CITY OF ALBUQUERQUE

May 10, 2022

Re: Murphy (Oil) Express
10601 Unser Blvd NW
Traffic Circulation Layout
Engineer's Stamp 05-03-2022 (A11-D017A)

SHEET NO. C-3

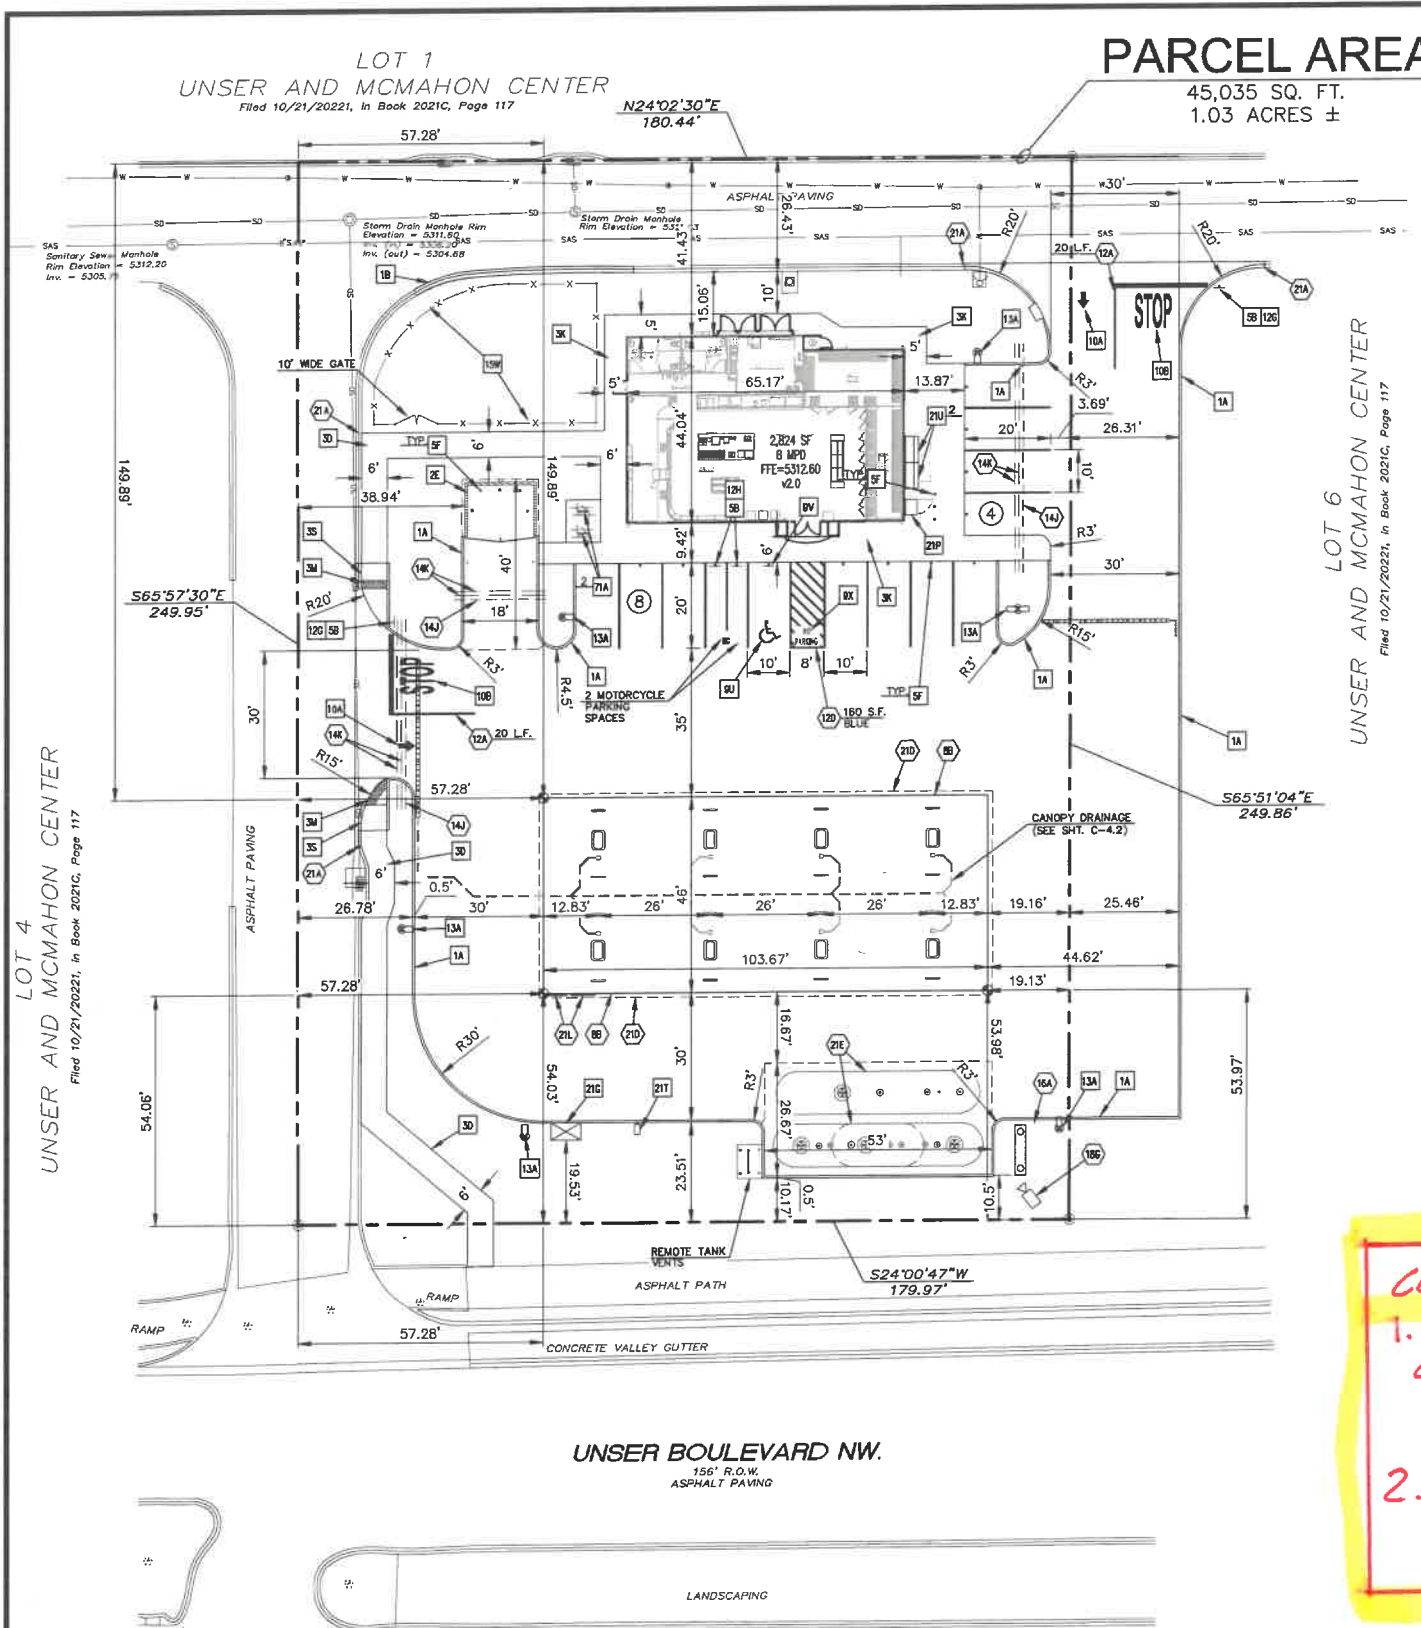
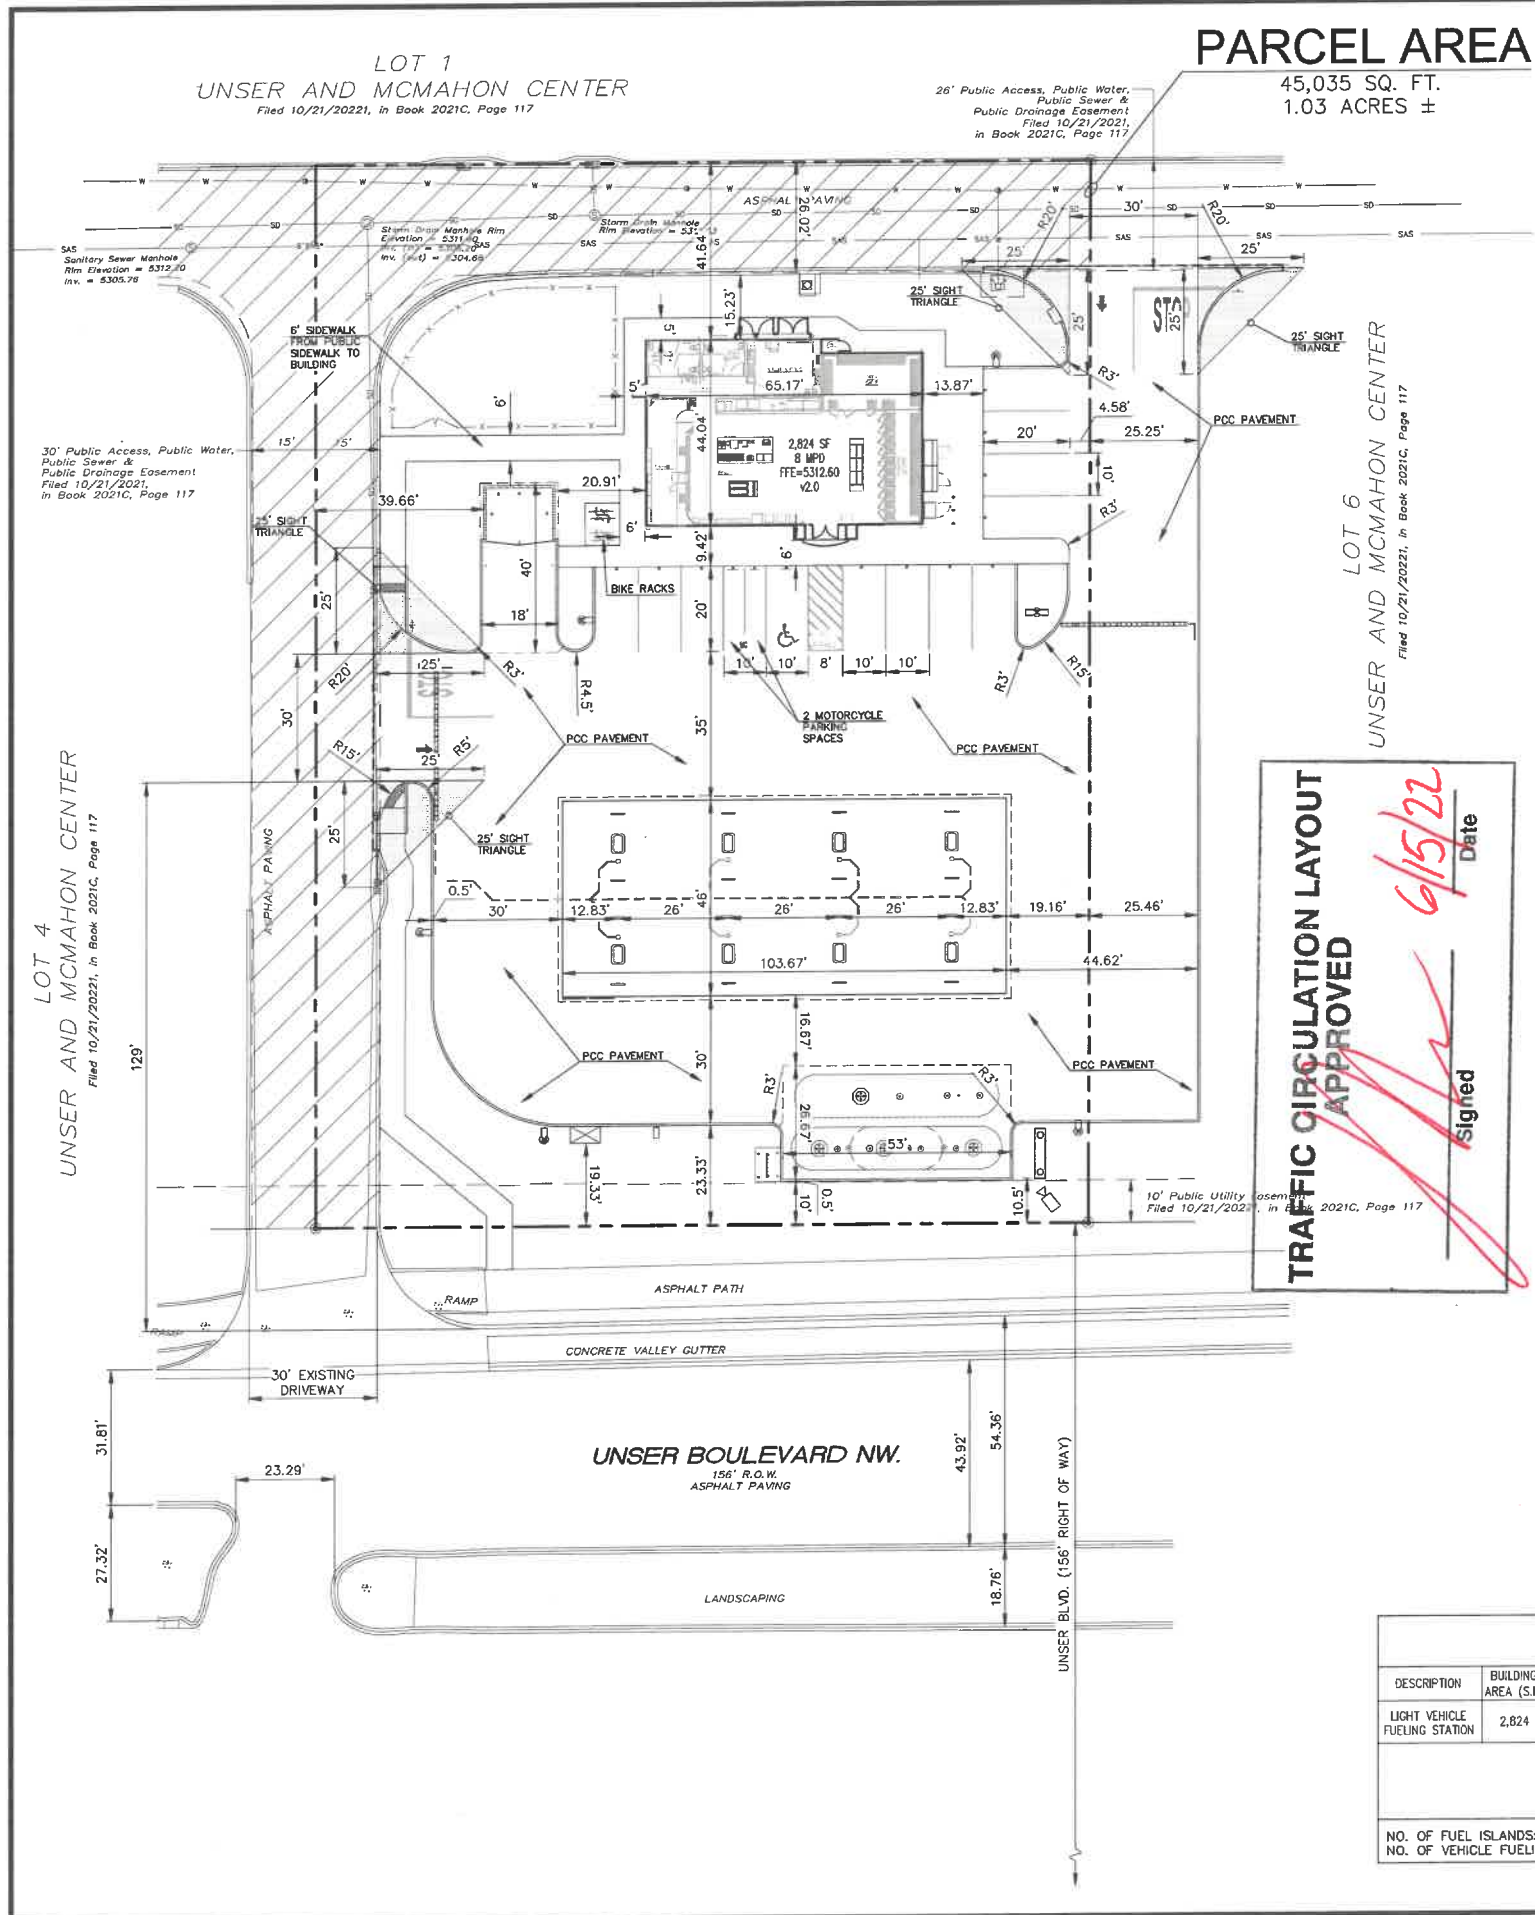
- Entrance width is too wide. Please adjust for two way traffic and delivery vehicle.
5. Site Notes and Details (sheet C-3) : You will need to reference all proposed infrastructure including striping, pavement markings details from the proposed detail sheets (Sheets 9 & 10).

6. Site Note 51B (sheet C-3): Provide this note.
7. Site Note 18G (sheet C-3): The location of this proposed item will need to be located within private property. Please make sure that it isn't within the vicinity of COA ROW limits including air space limits.

15. Provide a copy of refuse approval.
16. Fire Department: An approval Fire 1 plan needs to be provided.
17. It is not apparent what type of pavement surface is being proposed. A hard driving surface will be required as part of this proposed project for parking area and drive aisles (sheet C-3).
